**Minto Resource Recovery Facility (SSD-5339)
Response to Submissions**

**Re: SSD-5339 - Proposed Minto Resource Recycling Facility
No. 7 MONTORE ROAD, MINTO**

WORKSHOP SHED

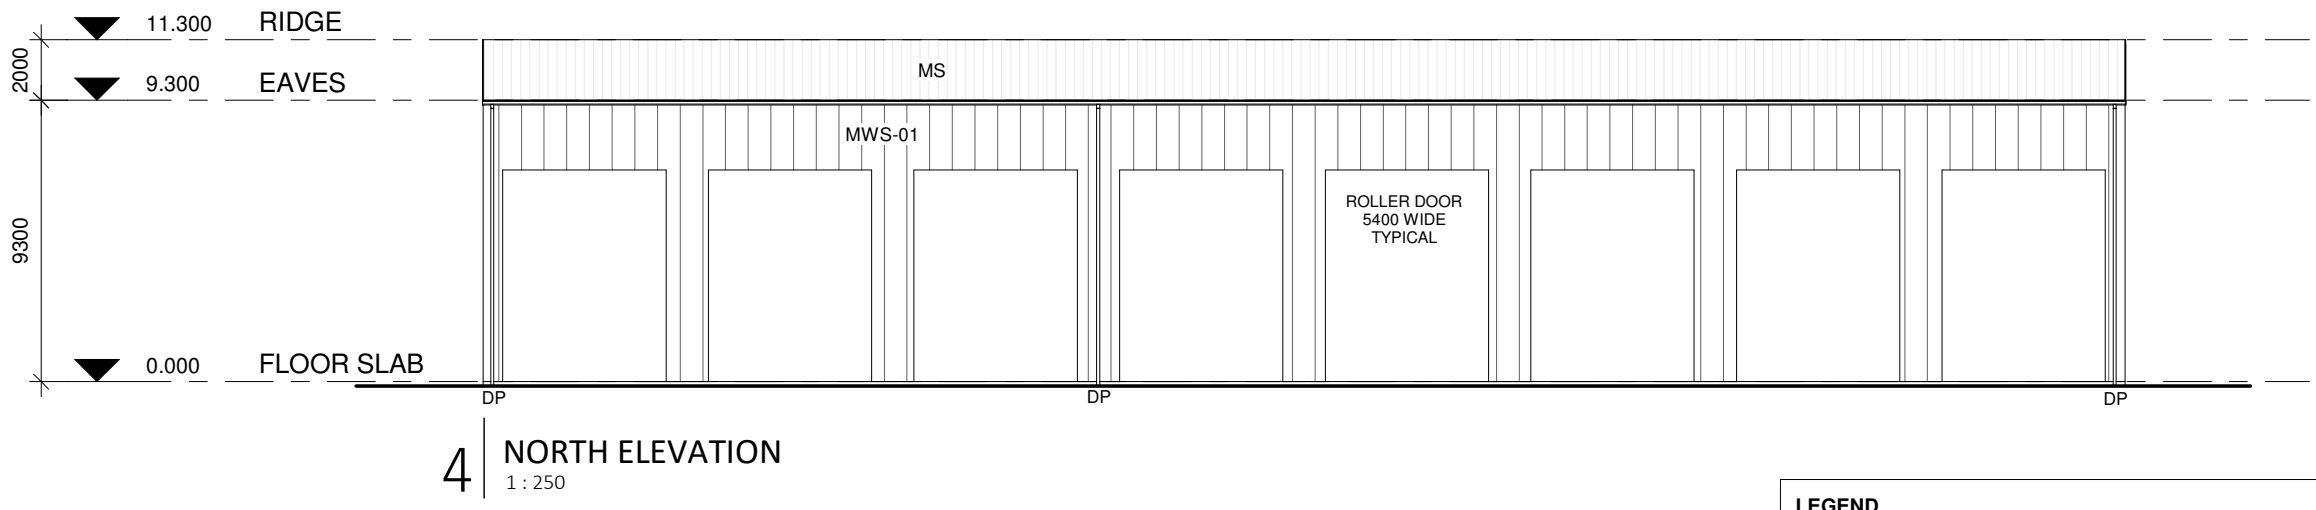
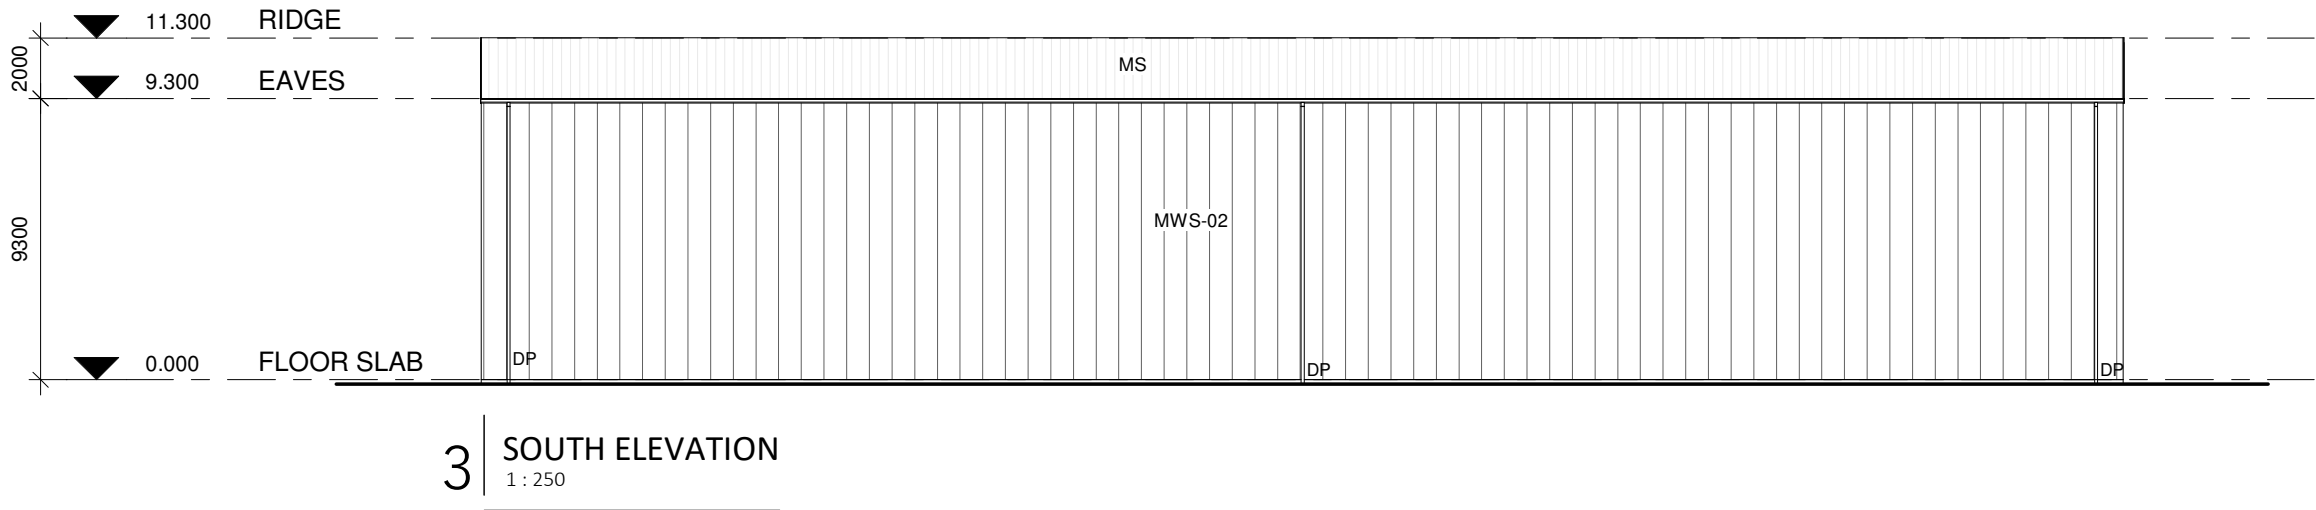
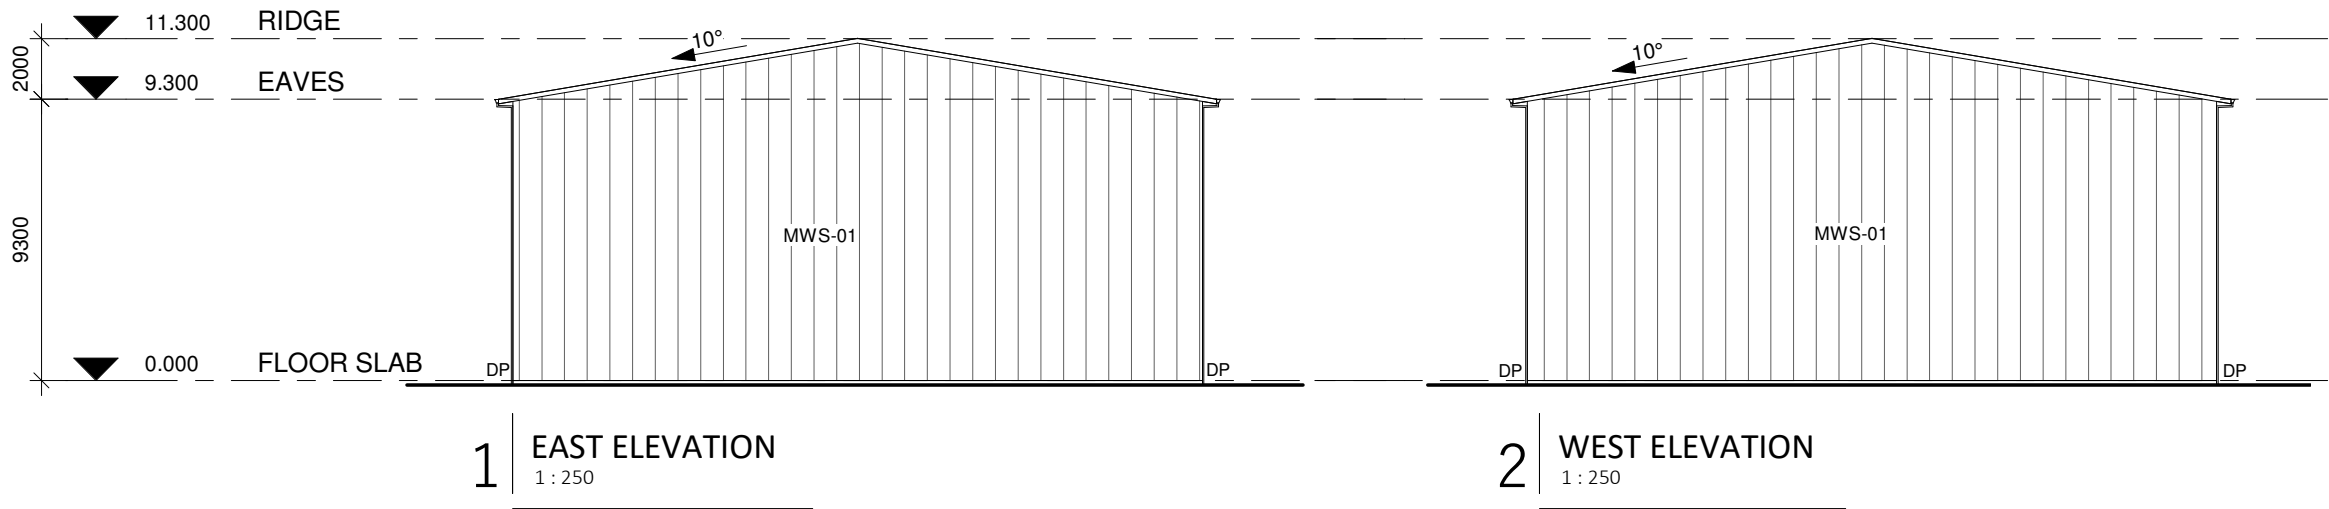
- Provide architectural drawings including elevations of the workshop, sand shed and any other permanent structure on site.
- Please label the tip and spread area on a plan to demonstrate that it will be separated from the larger waste stockpiles and that its size will be sufficient to meet the requirements of the EPA's *Standards for Managing Construction Waste*.
